Application for a Non-Material Amendment Following a Grant of Planning Permission

P23/02447/F

I refer to planning application ref. P23/02447/F at 17 Gloucester Road North, Filton, Bristol, BS7 0SG. SGC granted the application for 'Installation of 2no. front dormer windows, 1no. rear dormer window with balcony and erection of a single storey rear extension with roof balcony to facilitate the formation of 3no. new flats (Class C3) and partial change of use from Class E to Class C3 living accommodation with other associated works' on 13 October 2023. I attach the decision for your reference.

Scale(s): 1 : 50	Size: A1	Date: 20/04/23	Drawn by: Author
Drawing: number: P21853 / P/323	Revision: D	Chkd by: Checker

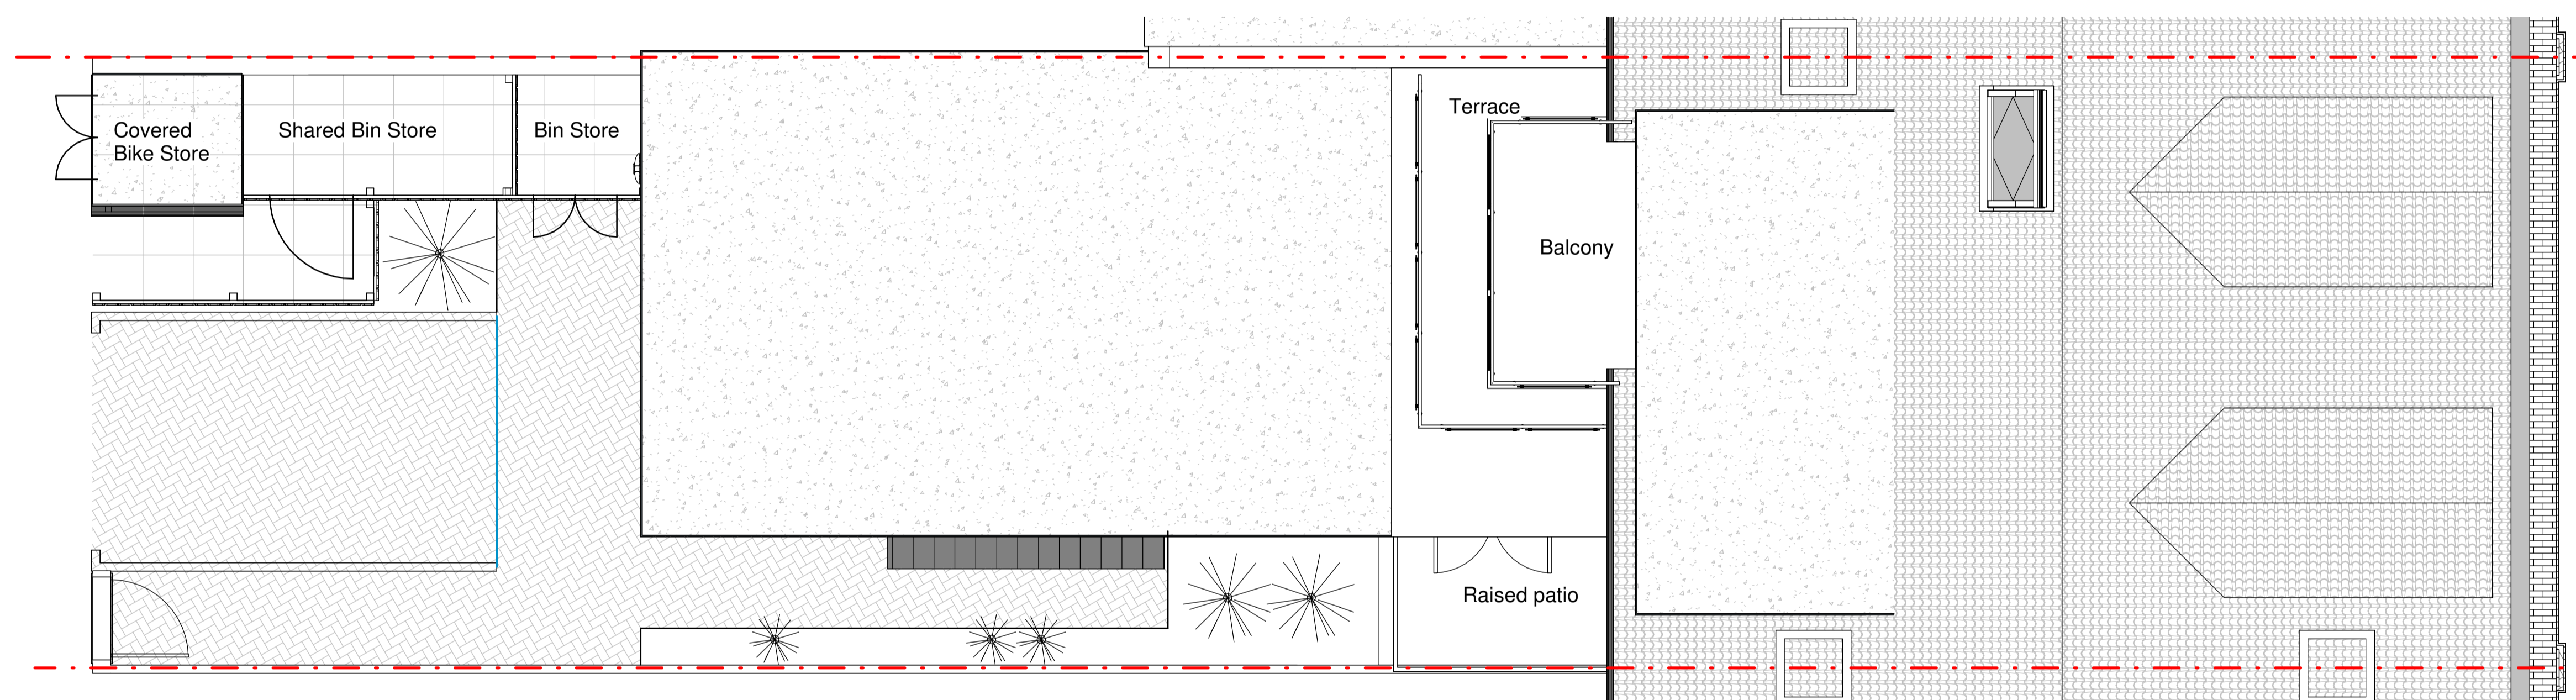
- Unit 1 (ground floor unit at rear of property): Permitted rooflights in living room and bedroom are omitted.
- Unit 2 (ground floor unit behind retail unit): Unit is replanned. Permitted rooflight is omitted. A high level window is proposed from the living room allowing for far reaching views. External double doors from the living room (obscured to prevent overlooking to neighbouring garden) and bedroom will allow natural light to enter the rooms.
- Unit 3 (second floor unit): Permitted roof terrace is slightly different shape, which is acceptable because the rooflights at Unit 1 are now omitted.

P21853 /P/323 Rev D – Roof and site plan (Replacing approved plan P21853 /P/323 Rev B – Proposed roof site plan)

Scale(s): 1 : 50	Size: A1	Date: 20/04/23	Drawn by: AW
Drawing number: P21853 / P/322	Revision: F	Chkd by: -

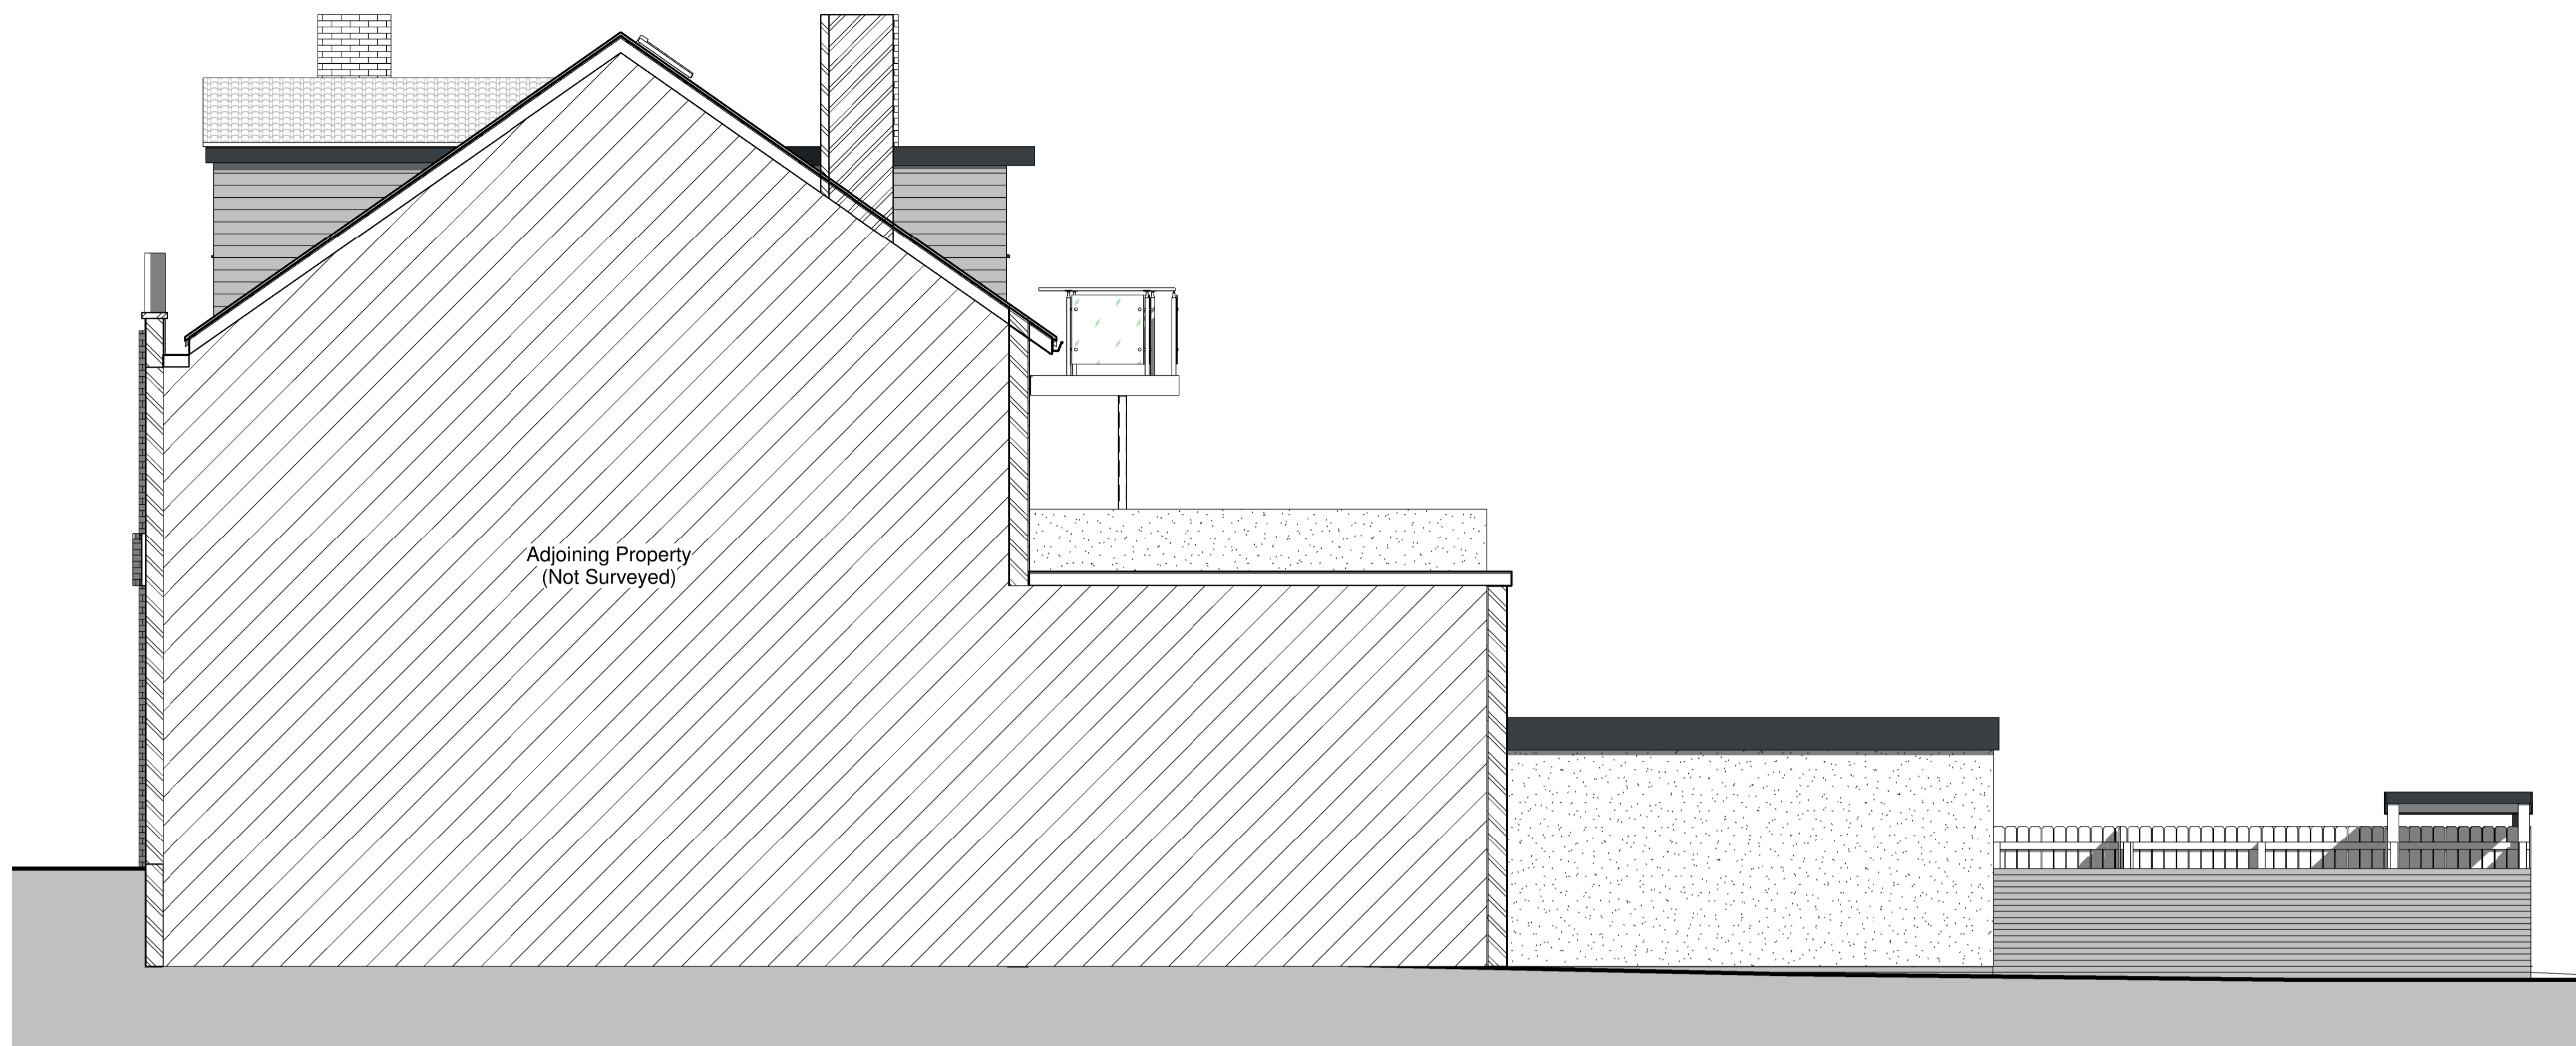
Plan no. P21853 /P/322 Rev F – Side elevations

Client: Harbourside Holdings Ltd			
Project title: Extension and Alterations, at 17 Gloucester Road North, Horfield, Bristol, BS7 0SG			
Drawing Elevation Drawing. Front and Rear Elevations			
Scale(s) 1 : 50	Size A2	Date: 23/11/23	Drawn AW
Drawing number: P21853 /P/321		Revision: F	Chkd by: -

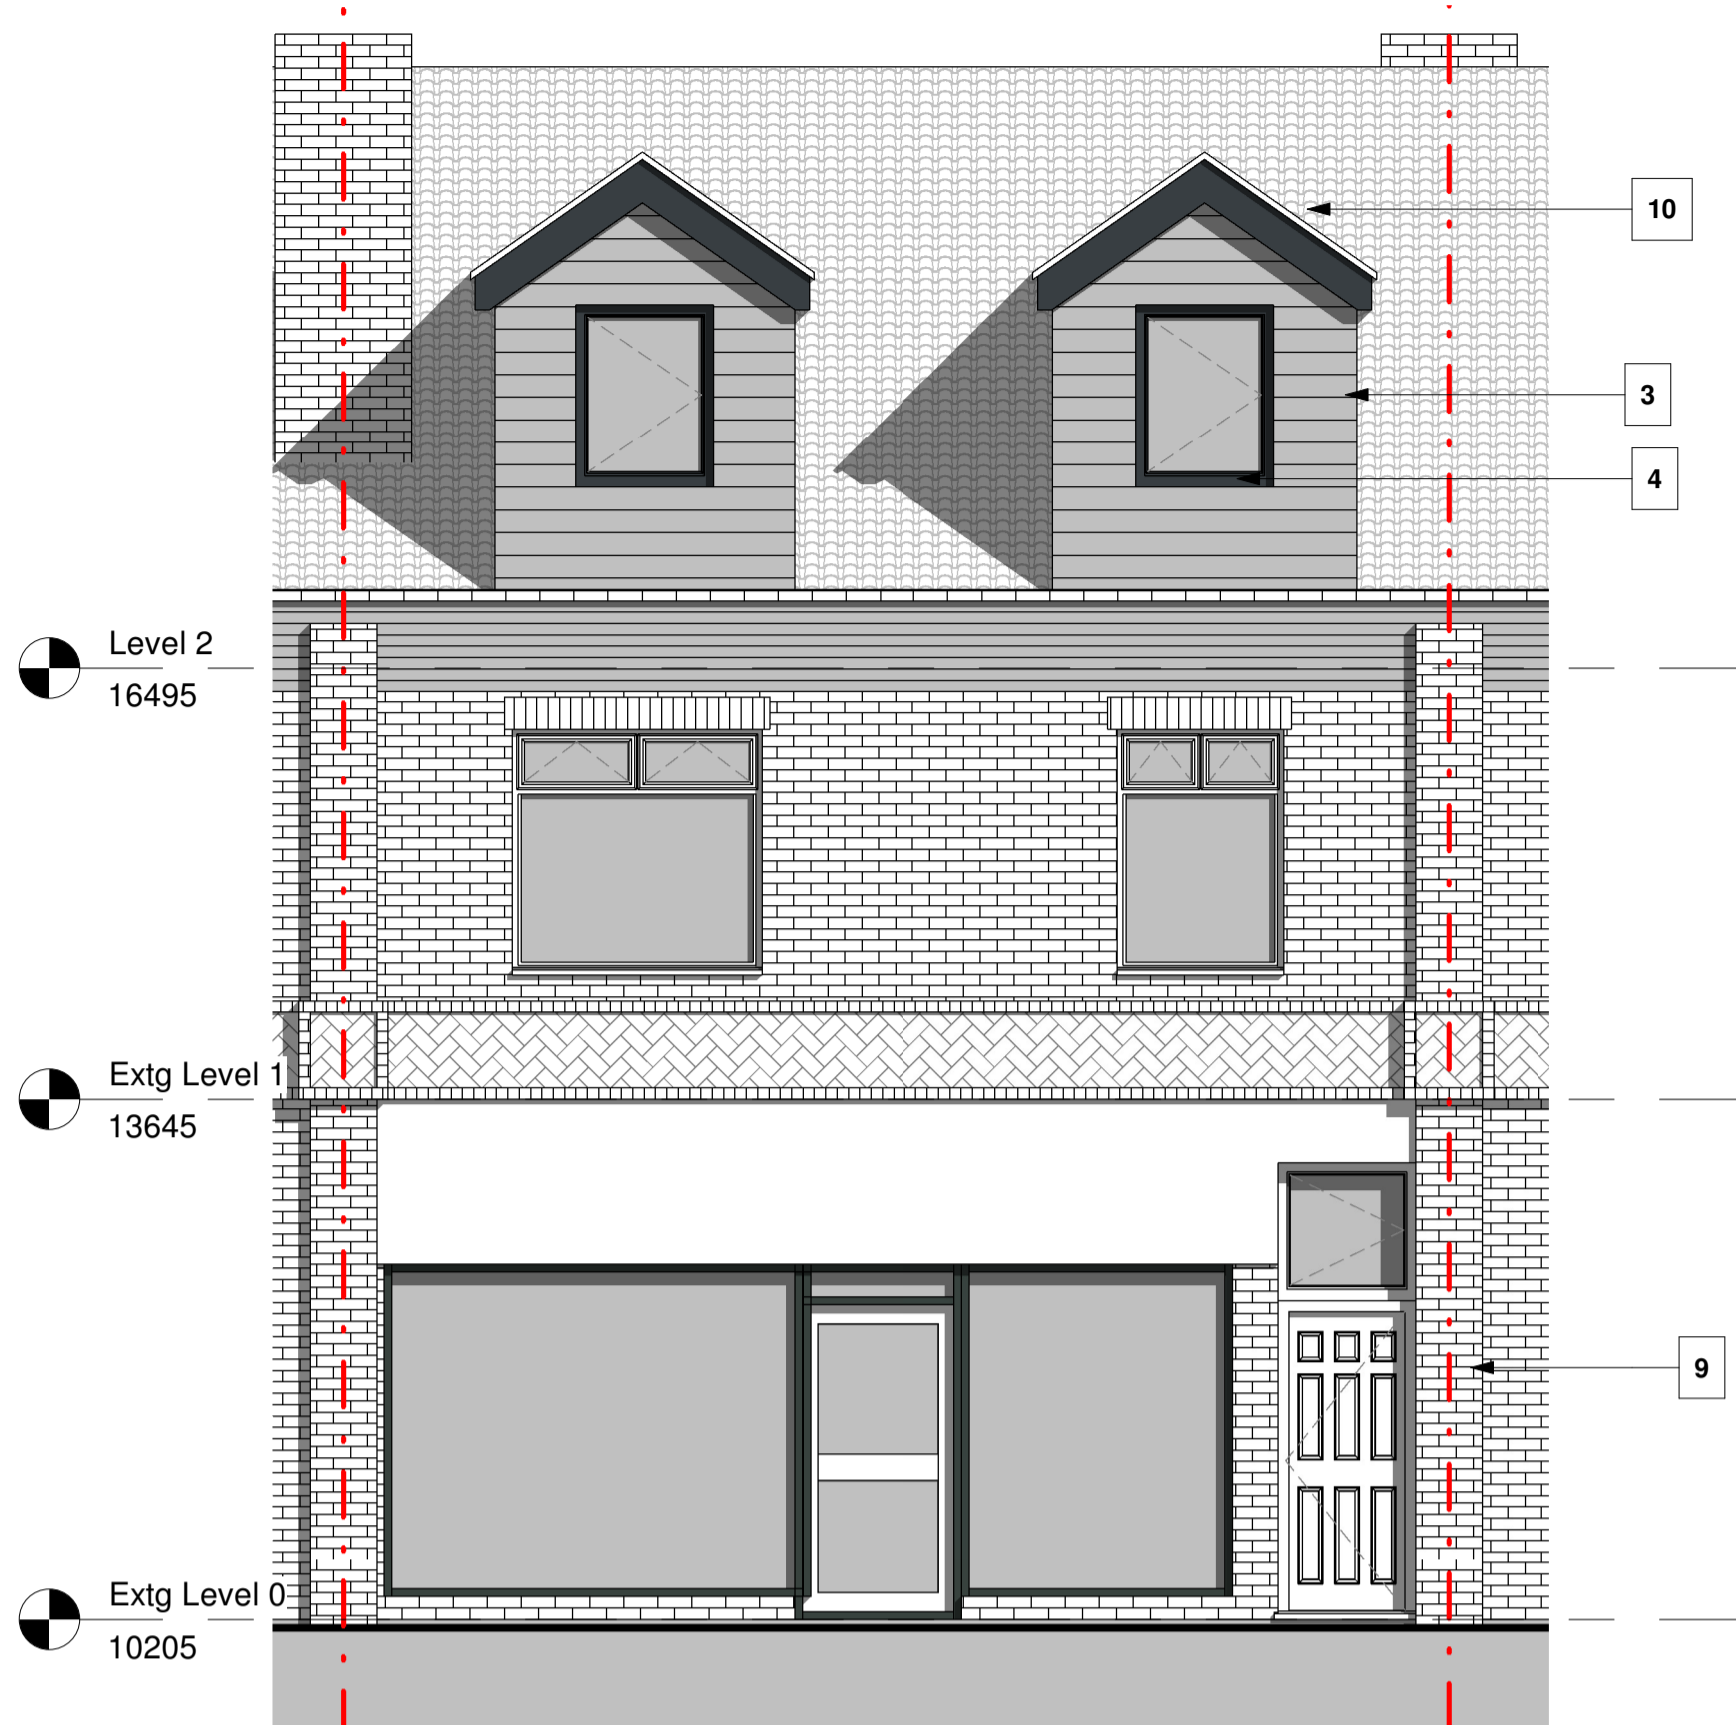
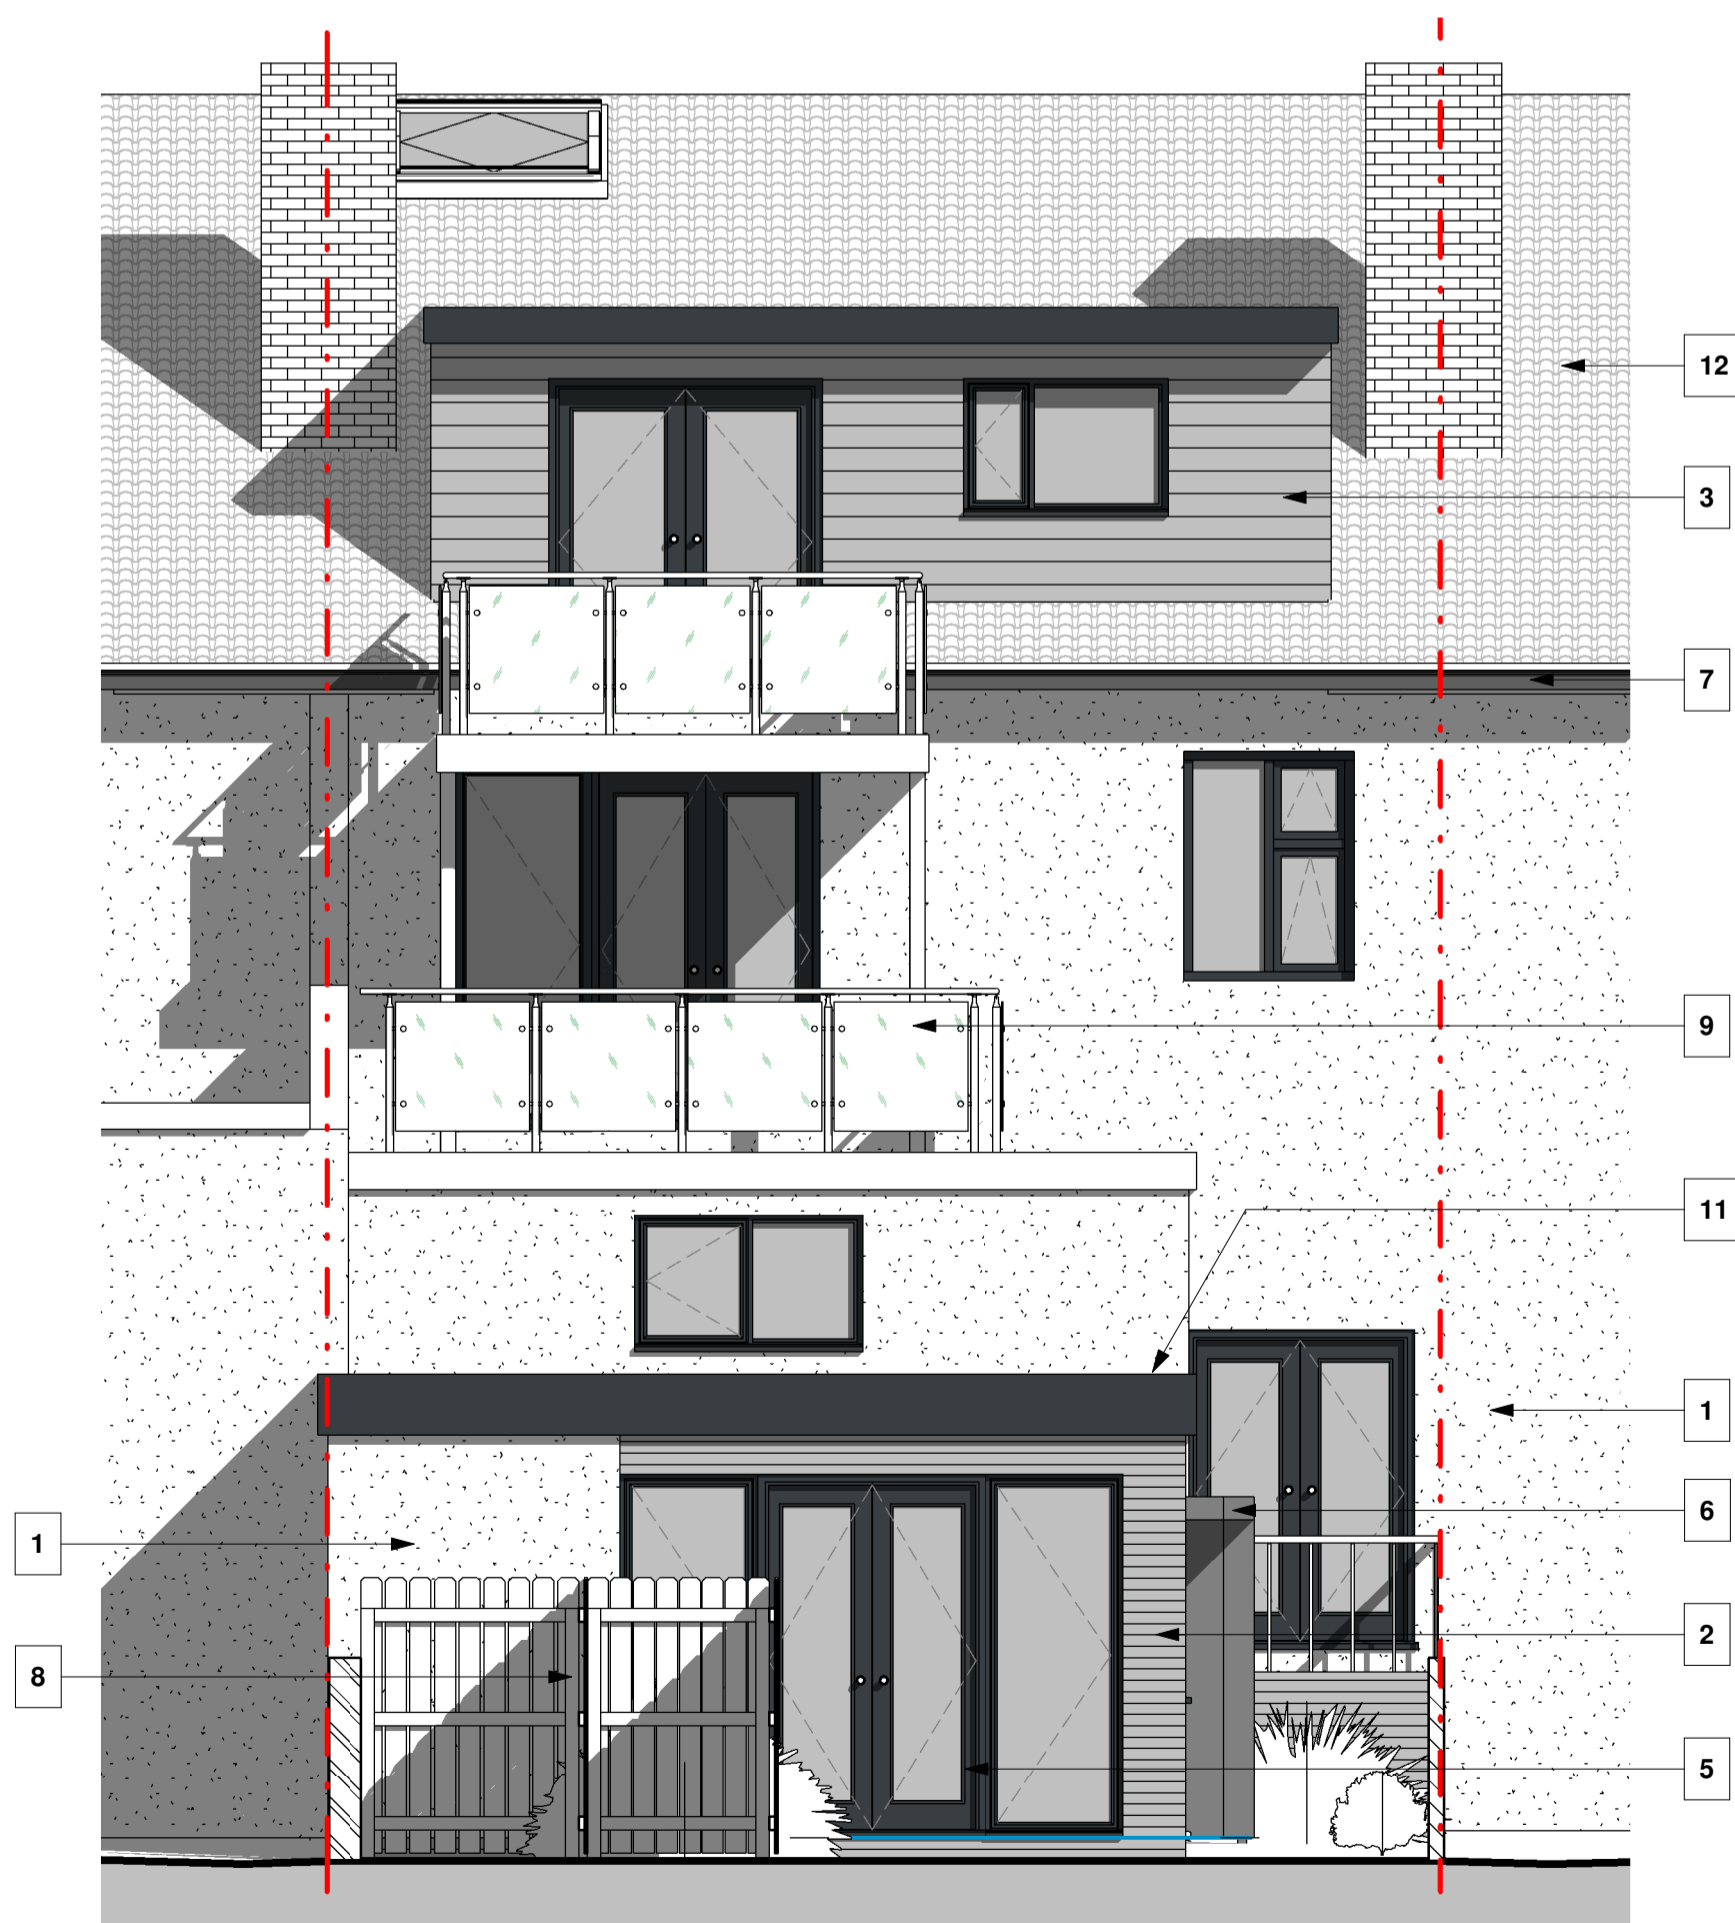
Plan no. P21853 /P/321 Rev F – Front and rear elevations
